Planning Application Ref: A/9/19/PL

Location: Pound Place, Roundstone Lane, Angmering, BN16 4AL

Description of works: Demolition of existing dwelling & erection of a 62 bedroom care home (C2 Residential Institution) with car park, landscaped gardens & access from Roundstone Lane (resubmission following A/51/18/PL).

TREE PROTECTION PLAN

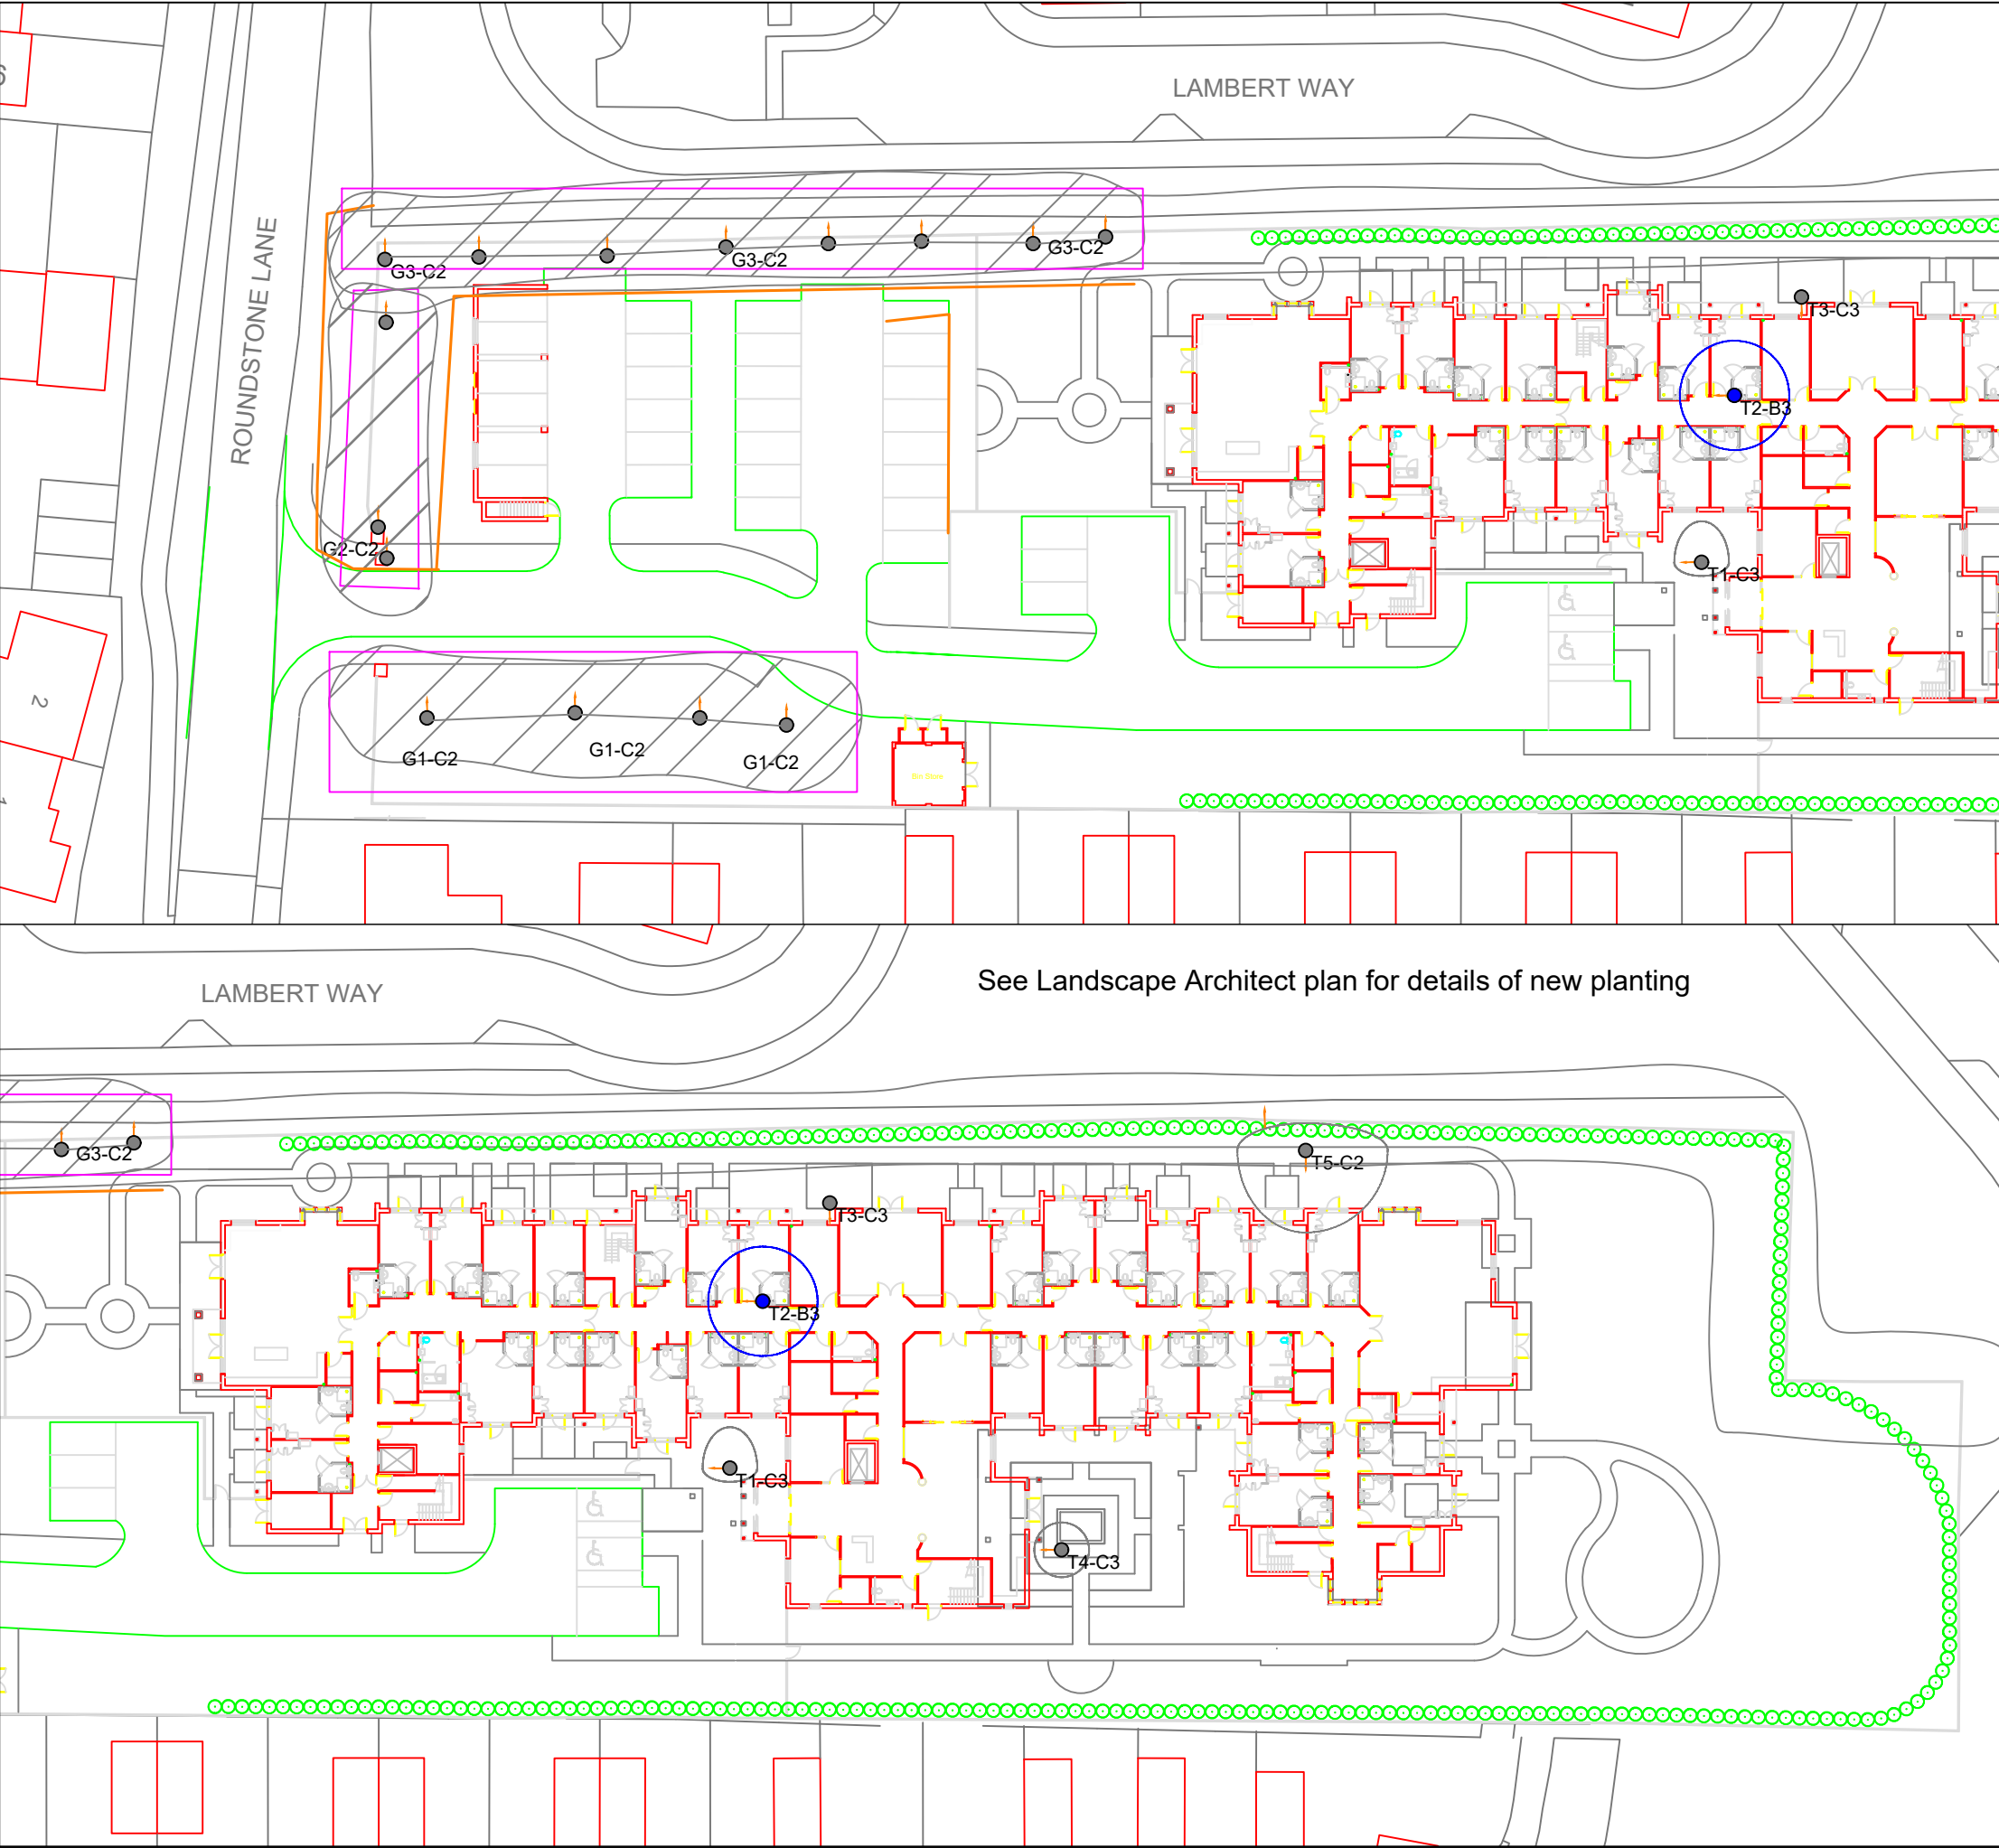
- I am pleased to note that superior tree group (G2) along the west boundary (adjacent Roundstone Lane) is to be retained. This will provide valuable screening throughout duration of any works and continue to add value to the street scene post-development.

- In respect of tree groups G1-G3 I accept that a degree of height reduction and trimming of lateral branches would be beneficial (to both mitigate the risk of future stem/branch failure events and improve conditions for adjacent dwellings) but suggest a maximum of 30% height reduction be permitted, where tolerable. A careful determination of any previous height reduction work should be made so that any further 'topping' does not create large wounds across parent stem diameter and is restricted to subsequent growth.

- Before the site is occupied or any machinery is introduced to the site or demolition work or construction work or alterations to existing ground levels takes place a **PRE-COMMENCEMENT Site Meeting** is to take place between the Arun DC Tree Officer and the Arboricultural Expert representing the site owners – at this meeting all protective fencing will be inspected to verify it is 'Fit for Purpose' as required under British Standard 5837:2012 and have been erected and positioned exactly as shown on the **Tree Protection Plan, Rev 1, dated 8th January 2019.**
